From: Morag Hoppe [REDACTED]
Sent: 13 September 2020
To: Amber Willard
Subject: FP/194/21/HH - 3 CULVER ROAD, FELPHAM

I am writing regarding the householder application recently submitted for 3 Culver Road.

Drawing No.	C848PC/HP/03		Rev.								
		Status

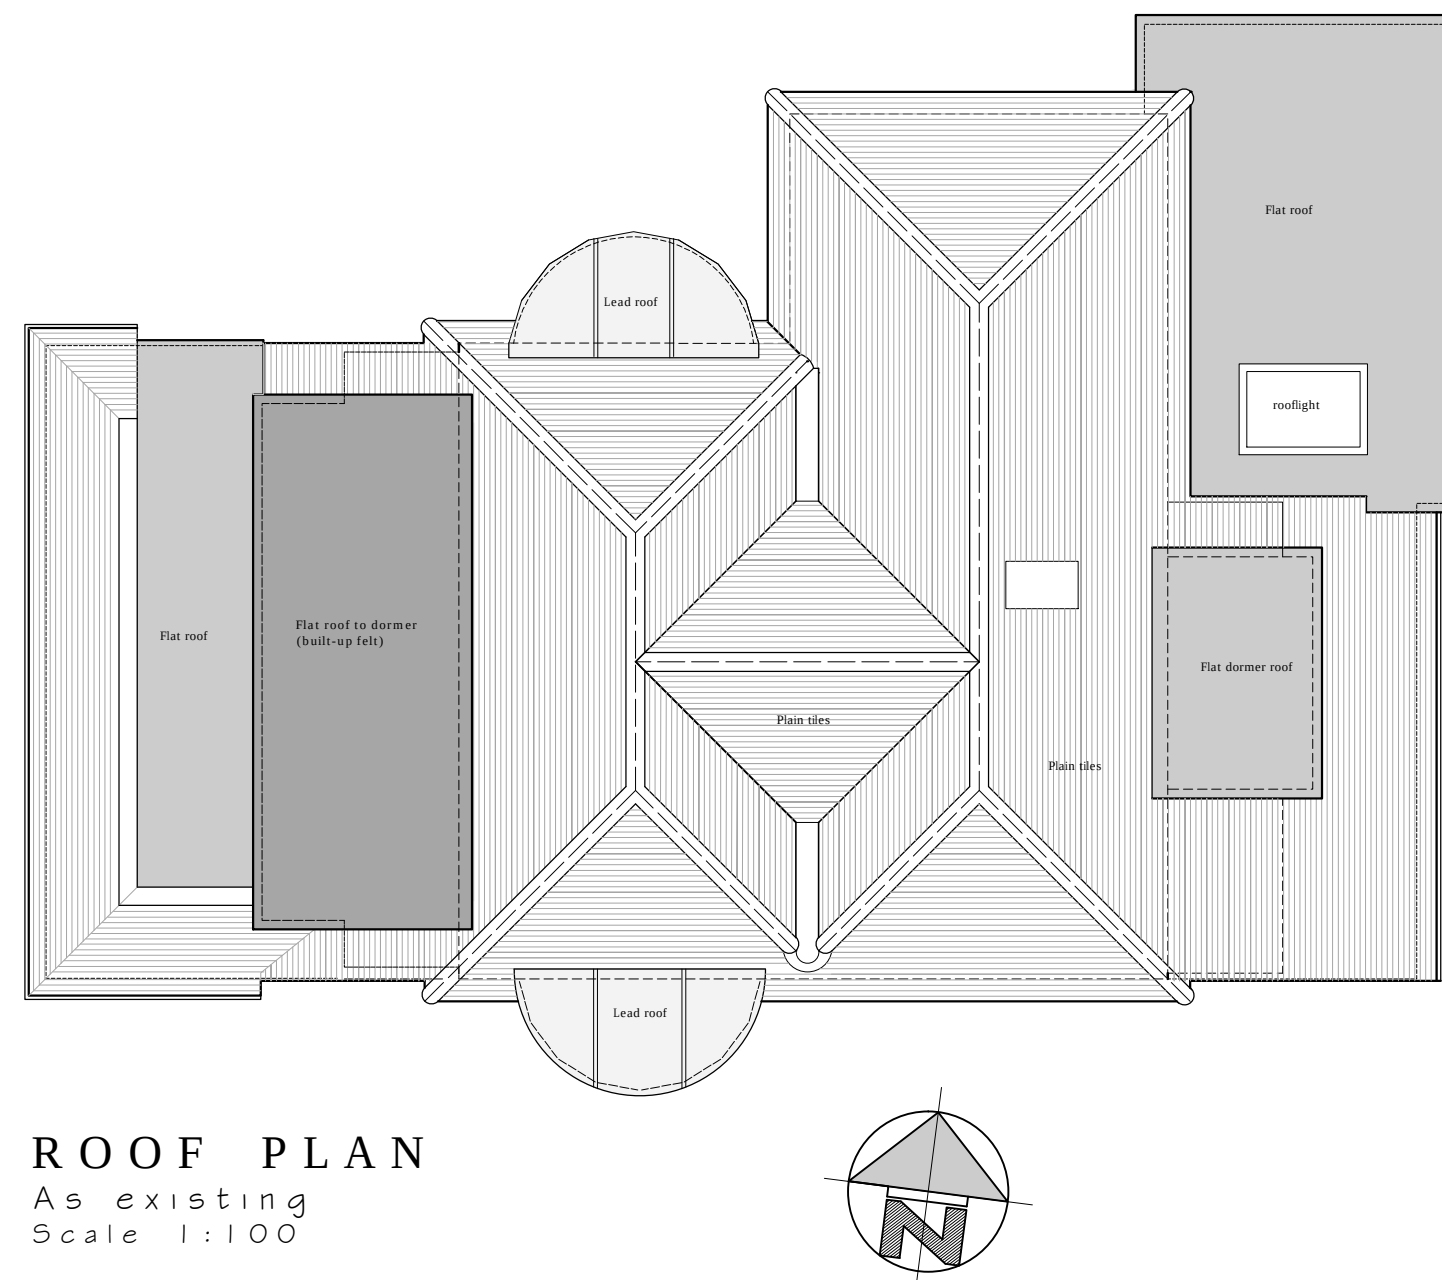
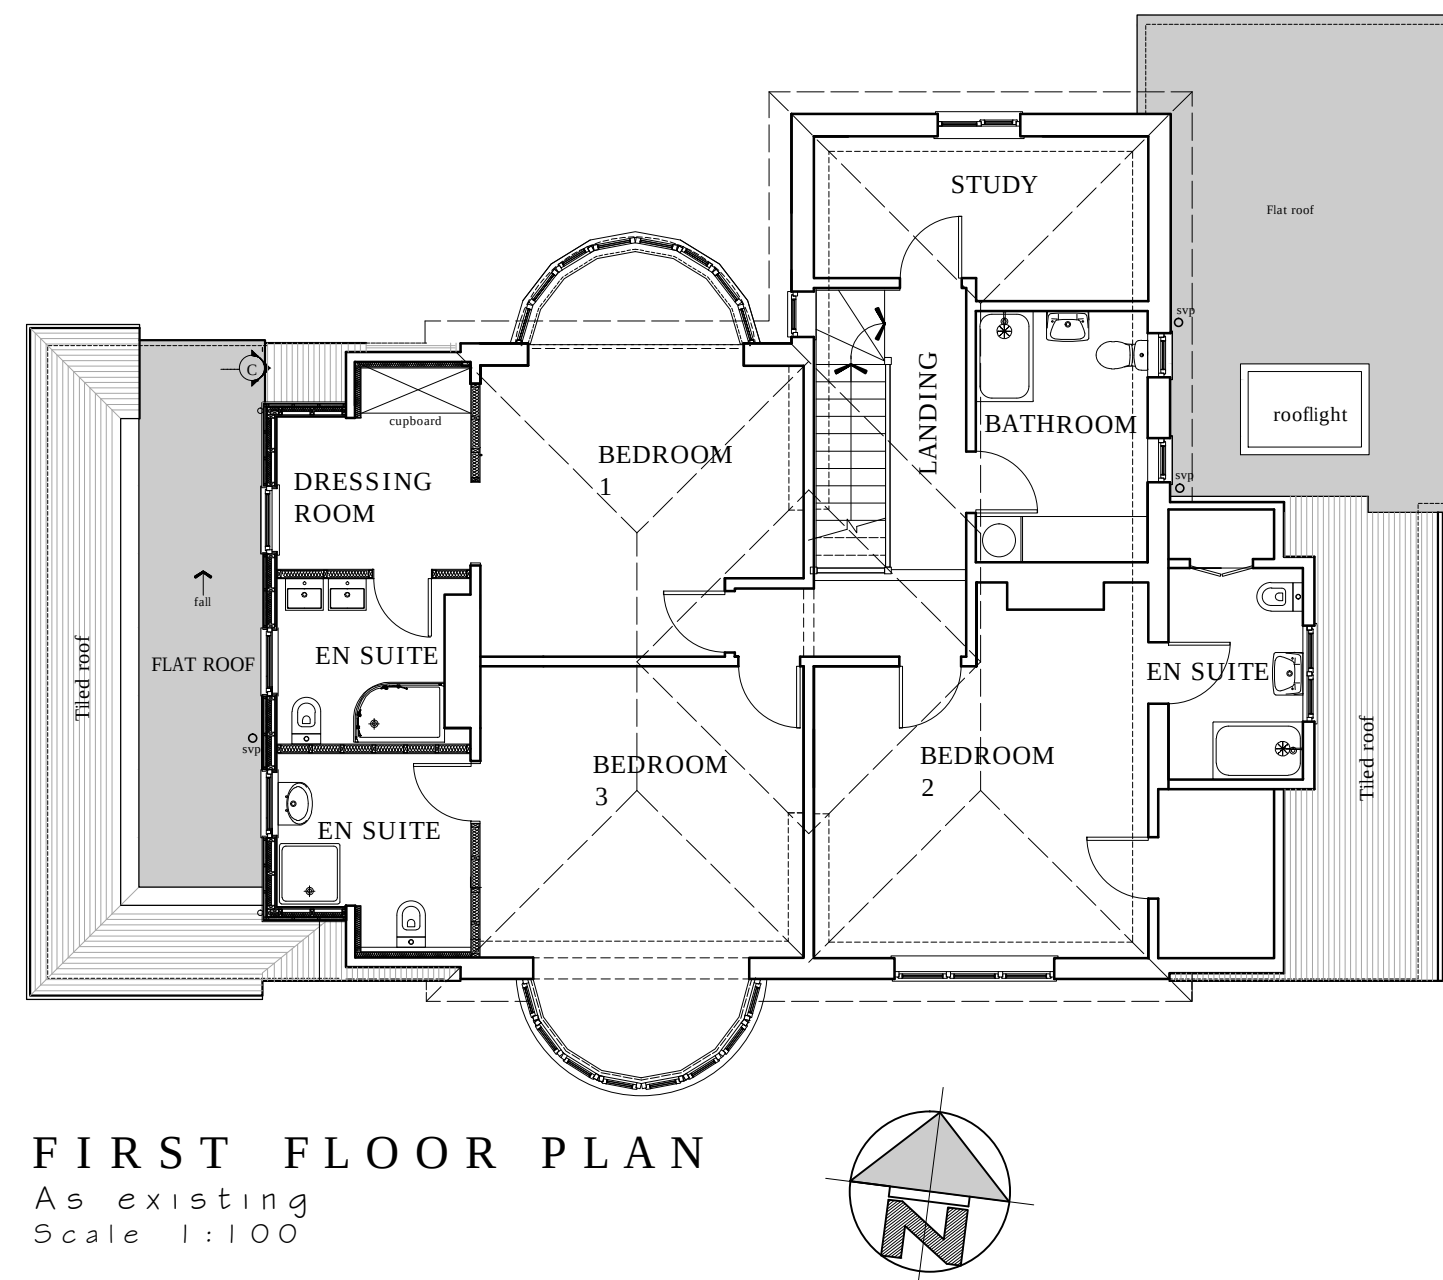
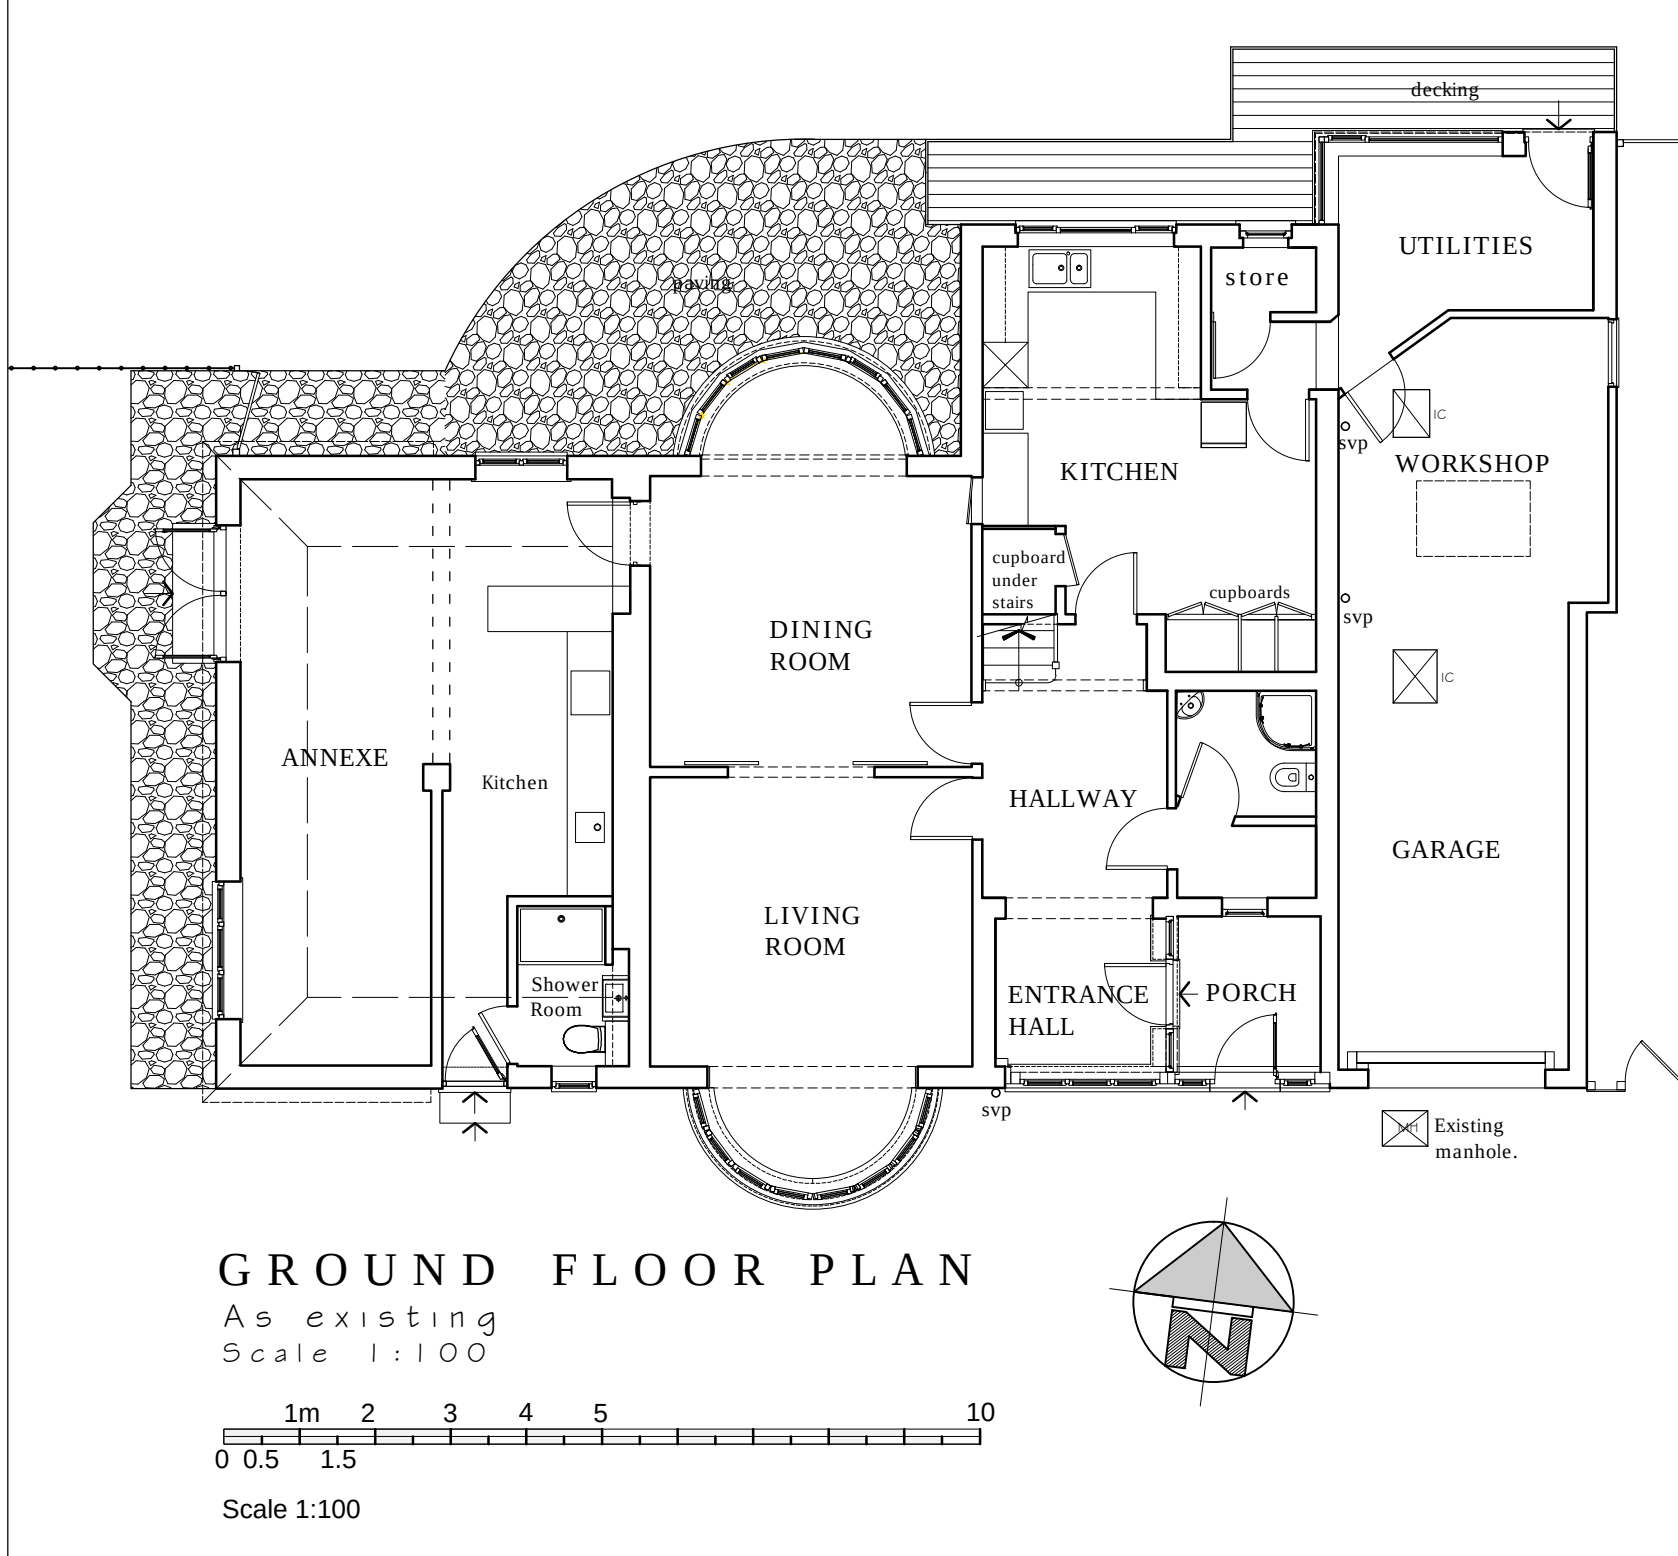
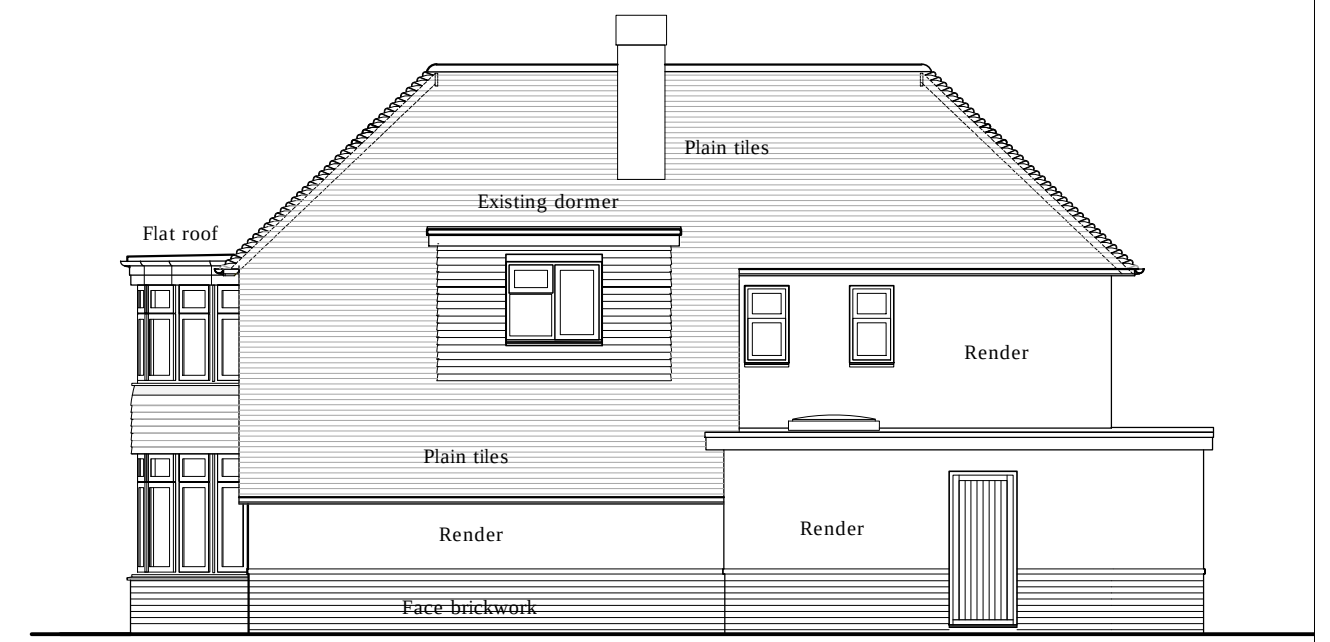
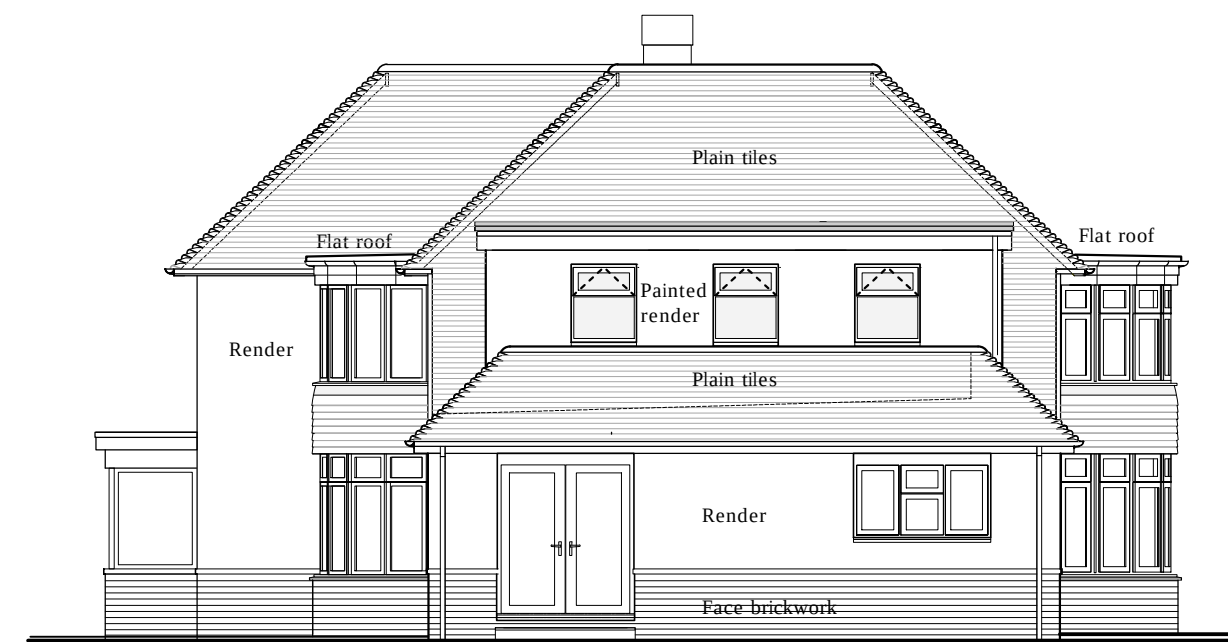
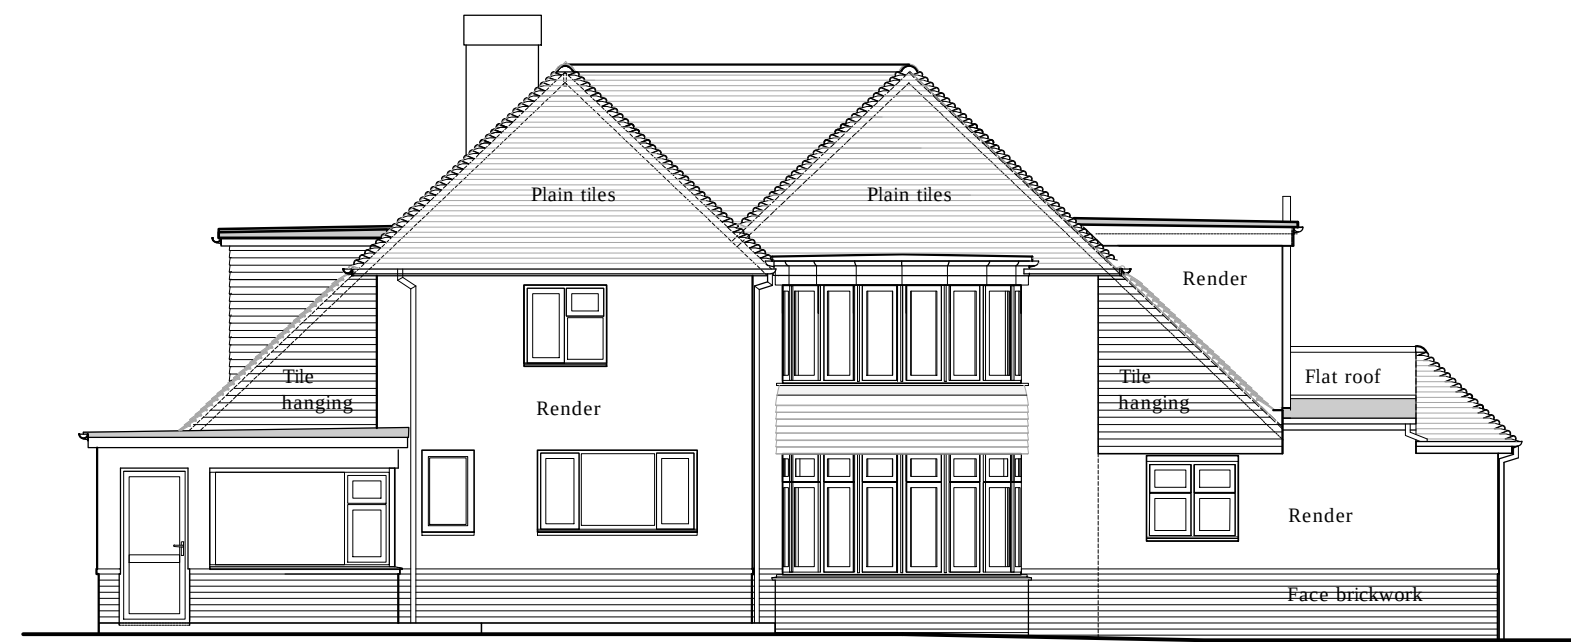
Our client (the applicant) Mr Buckley has asked me to notify you that the proposed colour for the new bi-fold doors in the extension is anthracite grey and not white.
